OXFORDSHIRE COUNTY COUNCIL'S RESPONSE TO CONSULTATION ON THE FOLLOWING DEVELOPMENT PROPOSAL

Application no: 15/00760/F

Proposal: Development of a new Local Centre comprising a Convenience Store (use class A1), Retail Units (flexible use class A1/A3/A5), Pub (use class A4), Community Hall (use class D1), Nursery (use class D1), Commercial Units (flexible use class A2/B1/D1) with associated Access, Servicing, Landscaping and Parking with a total GEA of 3,617 sqm

Location: North And South Arcade At Bicester Eco Town Exemplar Site Charlotte Avenue Bicester

Rendered Landscape Masterplan

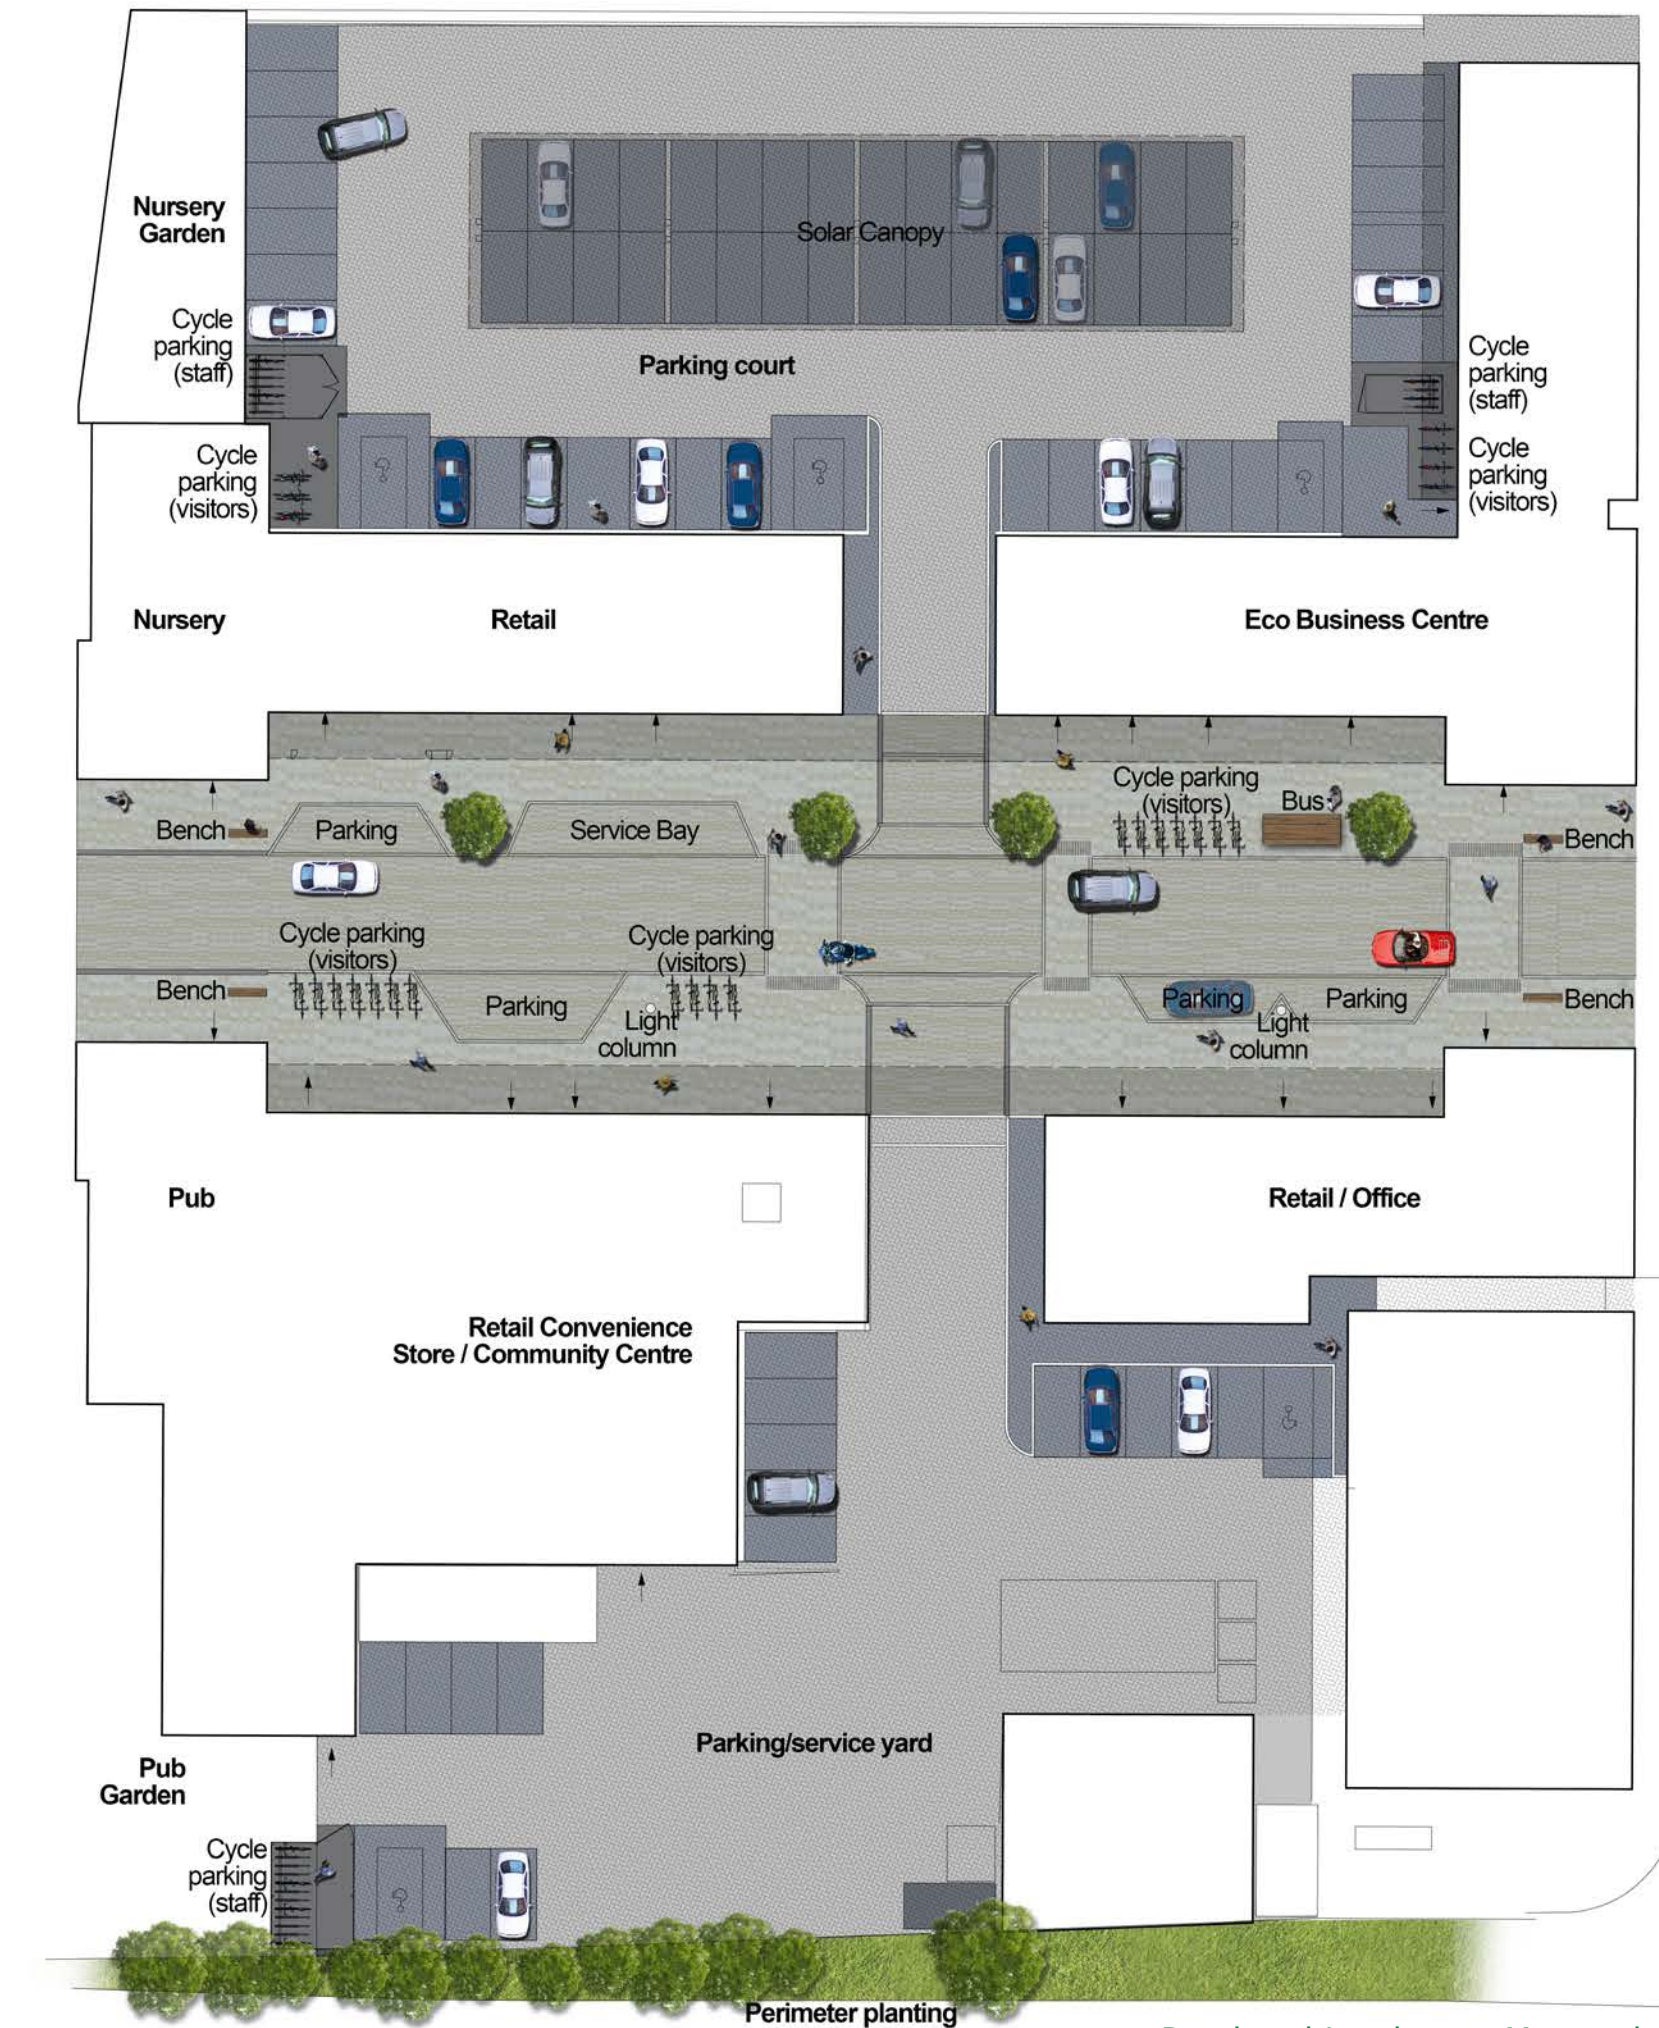
The materials shown on the Landscape Masterplan differ significantly from that what were approved in the spine road technical audit. Whilst there were expected to be some changes in the local centre material palette, none of the materials shown have yet been approved for use on the spine road. There are also significant changes in the layout with on street parking, trees and benches being introduced.

The S38 layout includes traffic calming to the West of the local centre which is not shown on the application landscape masterplan. There are also open drainage channels in the local centre area to the South of the spine road at the road edges.

The street lighting positions may have also changed and the street light in to the North of retail unit 4 now looks to be in a vulnerable location, where it is likely to be hit by manoeuvring vehicles.

The 'formal' crossing points in fact appear to be informal. Also they only show a change in paving element size rather than a change in colour. Unless there is significant contrast in the road surface colour or some other warning, vehicle drivers will assume priority. They need to be very clearly differentiated or not marked on the carriageway at all. Particularly given the HGV use, I would prefer to see them further away from the turning into the service yard/car park.

The paving appears to be flush all the way across the adoptable areas. Kerb upstands would help prevent parking outside the designated bays and if there are no upstands some bollards or other deterrent may be required to prevent vehicles accessing the non-vehicular areas. The area in front of the nursery and directly opposite it could be especially vulnerable to use by goods vehicles and parents parking for the nursery. Along with the risk to pedestrian safety, consideration needs to be given to the risk of damage of the footway by goods vehicles.

The service bay appears to be too shallow and to have an inadequate taper. This should be redesigned with the size of intended vehicles in mind, and tracking provided. It may be more appropriate to switch the parking and servicing bays due to proximity of the service bay to the informal crossing and access to the car park (visibility concern).

The proposed street design would need to be the subject of a revision to the S38 agreement, which would require further technical audit. It would be helpful for the applicant to confirm the areas proposed to be offered for adoption. The landscape masterplan appears to indicate a colonnade on both sides – areas underneath this could not be adopted.
